**Case Officer:** Linda Griffiths

**Applicant:** L & Q Estates

**Proposal:** Reserved matters application for 14/01932/OUT - foul sewer pumping station along with associated landscaping and access

DATE: 15<sup>th</sup> June 2022

TITLE
**PUMPING STATION
GENERAL ARRANGEMENT**

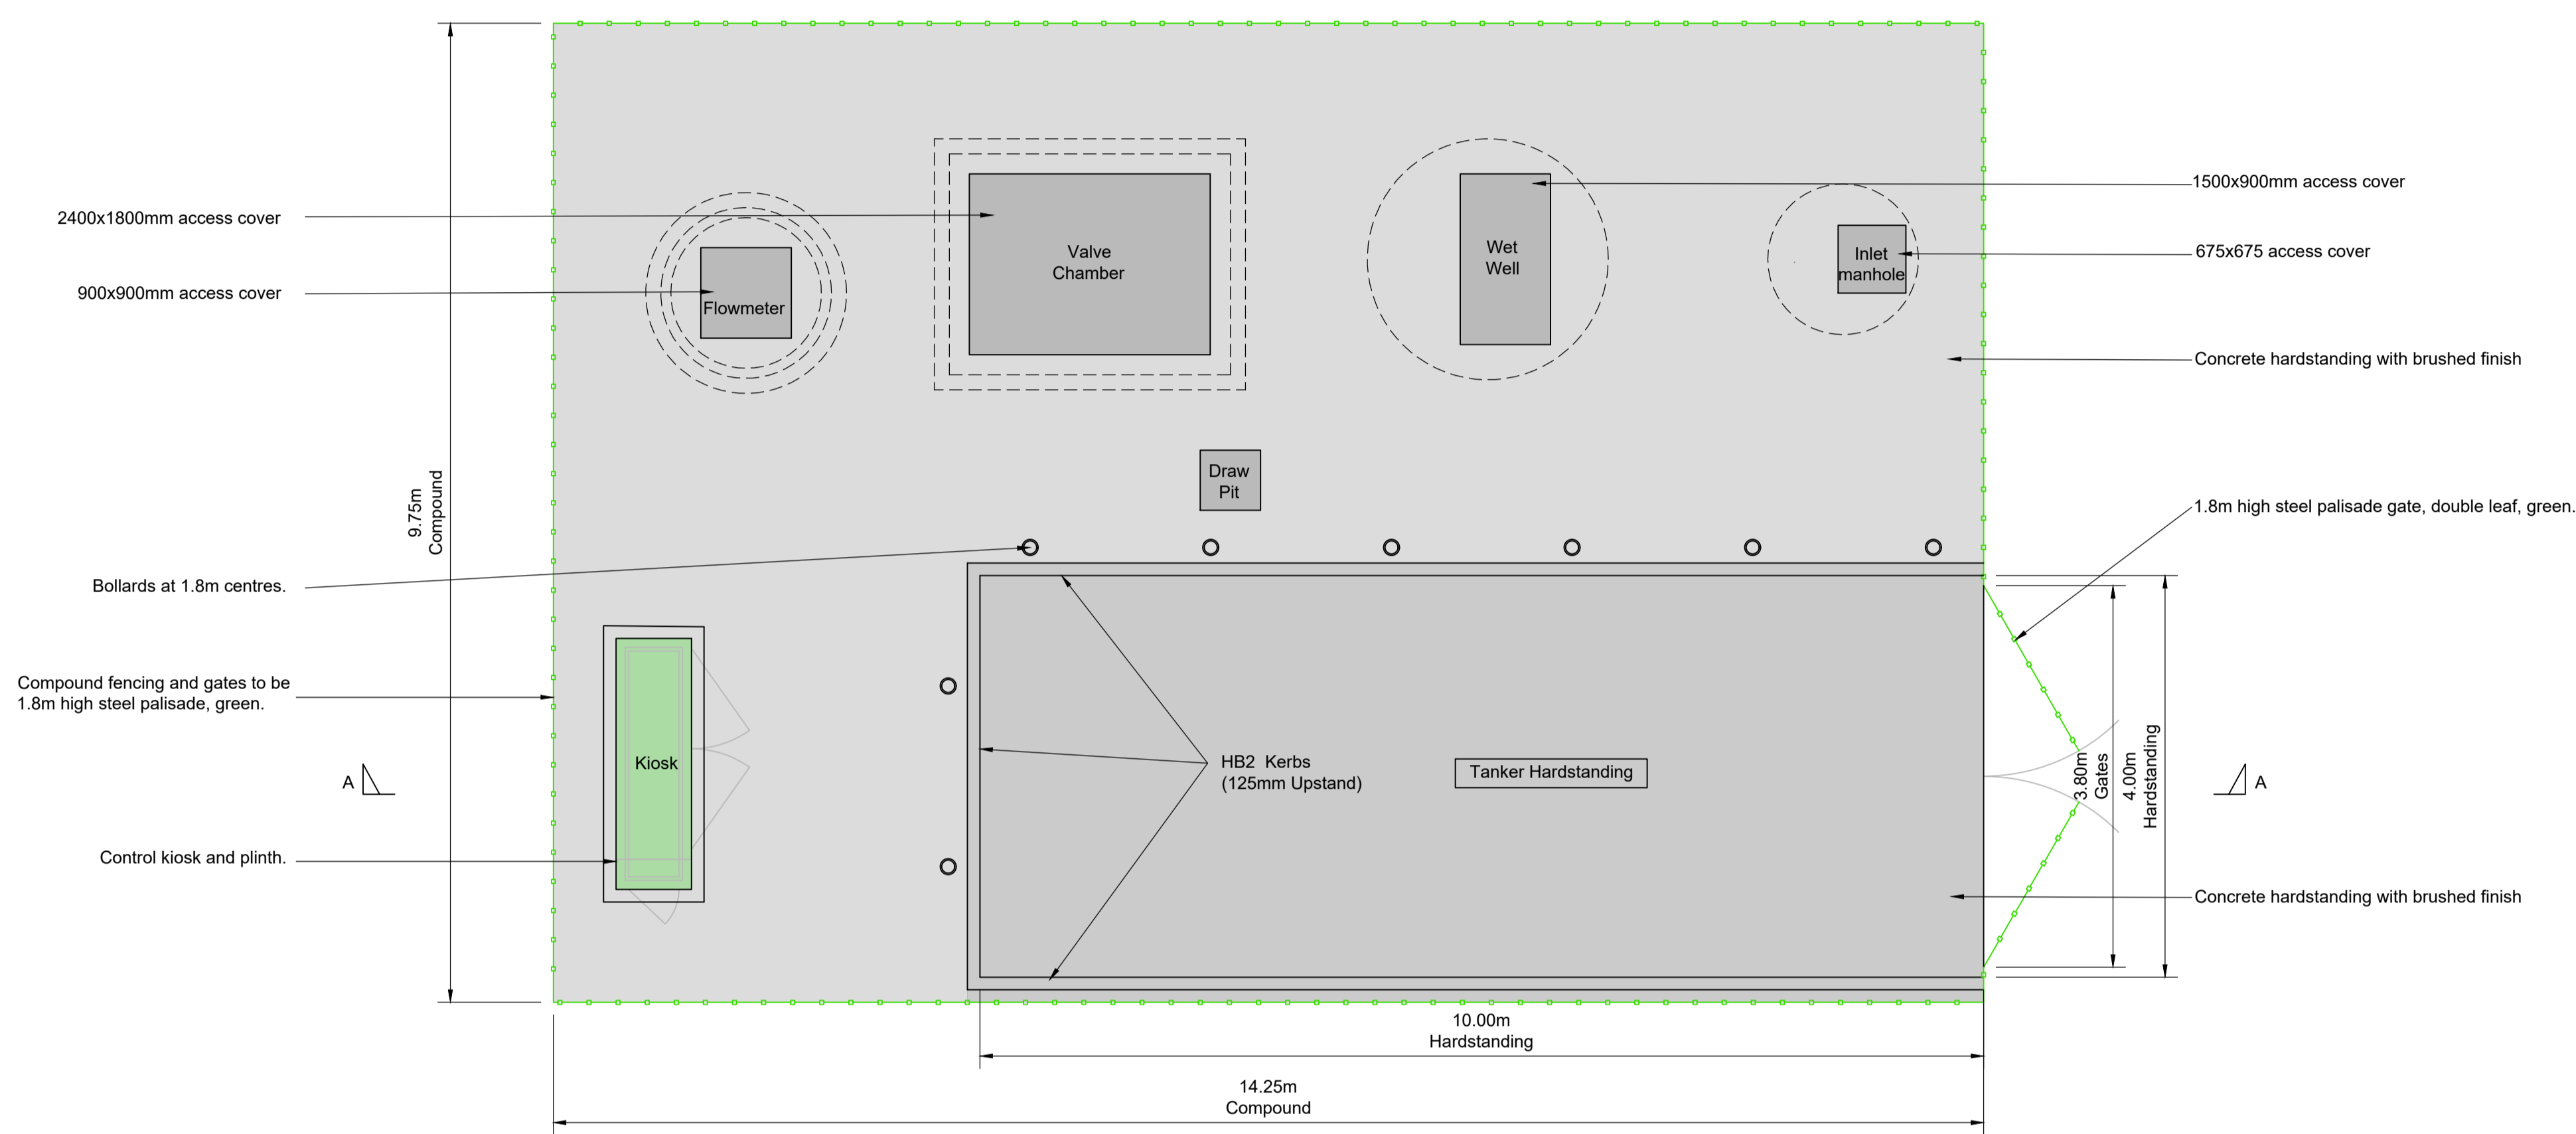
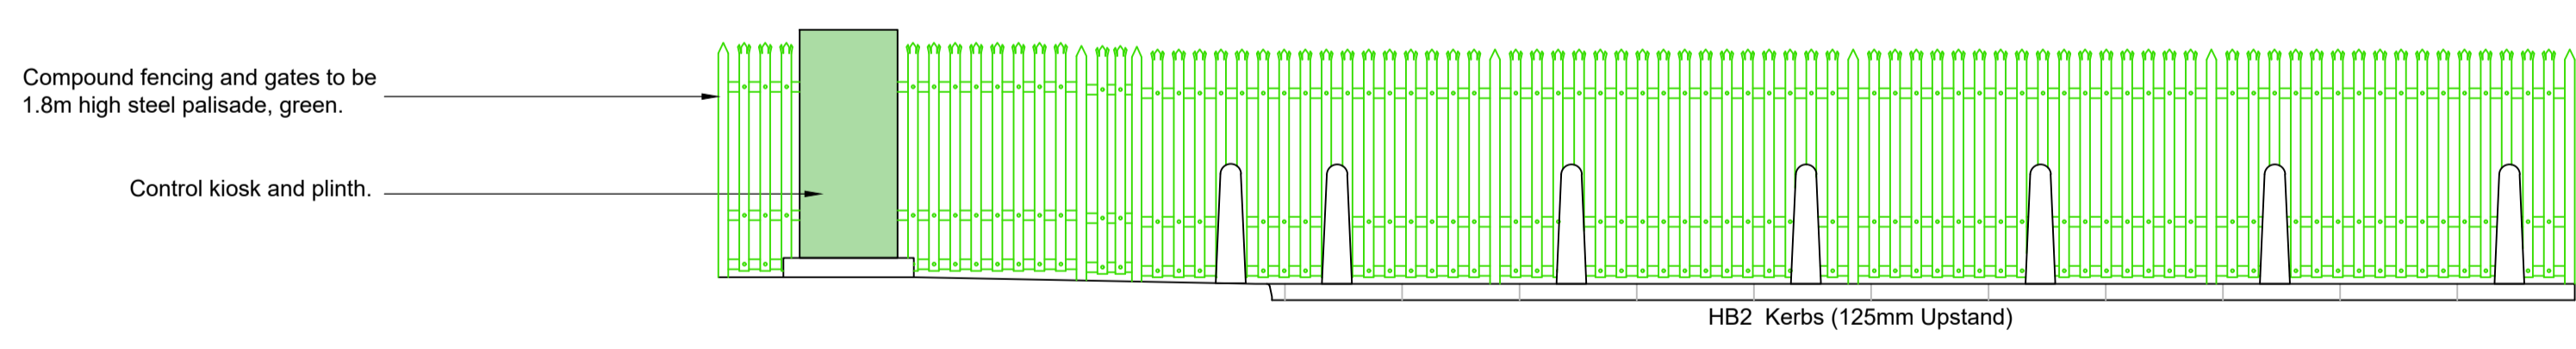
8.7. The proposed vehicular access to the pumping station which is proposed directly from the main spine road will also serve the allotments, which will be provided on land to the south of the pumping station. The initial submission was assessed by

OCC as local highway authority who raised an objection. The allotments will provide car parking for users and as such, access must be suitable for two passing cars. Swept path analysis was also required demonstrating two family cars could pass one other along the access road and where this would not be possible, to provide passing places at sufficient intervals to properly accommodate vehicle conflicts. Visibility splays were also requested to demonstrate adequate vision at the site access joining the spine road.

- 8.8. Further to the above, a Technical Design Note prepared by Hydrock Consultants Limited has been submitted on behalf of Persimmon Homes, which includes 2 revised drawings showing the visibility splay and a 4.1m access track to allow 2 cars to pass. OCC has since confirmed that the amended plans have addressed the objection and that the proposals are now acceptable.
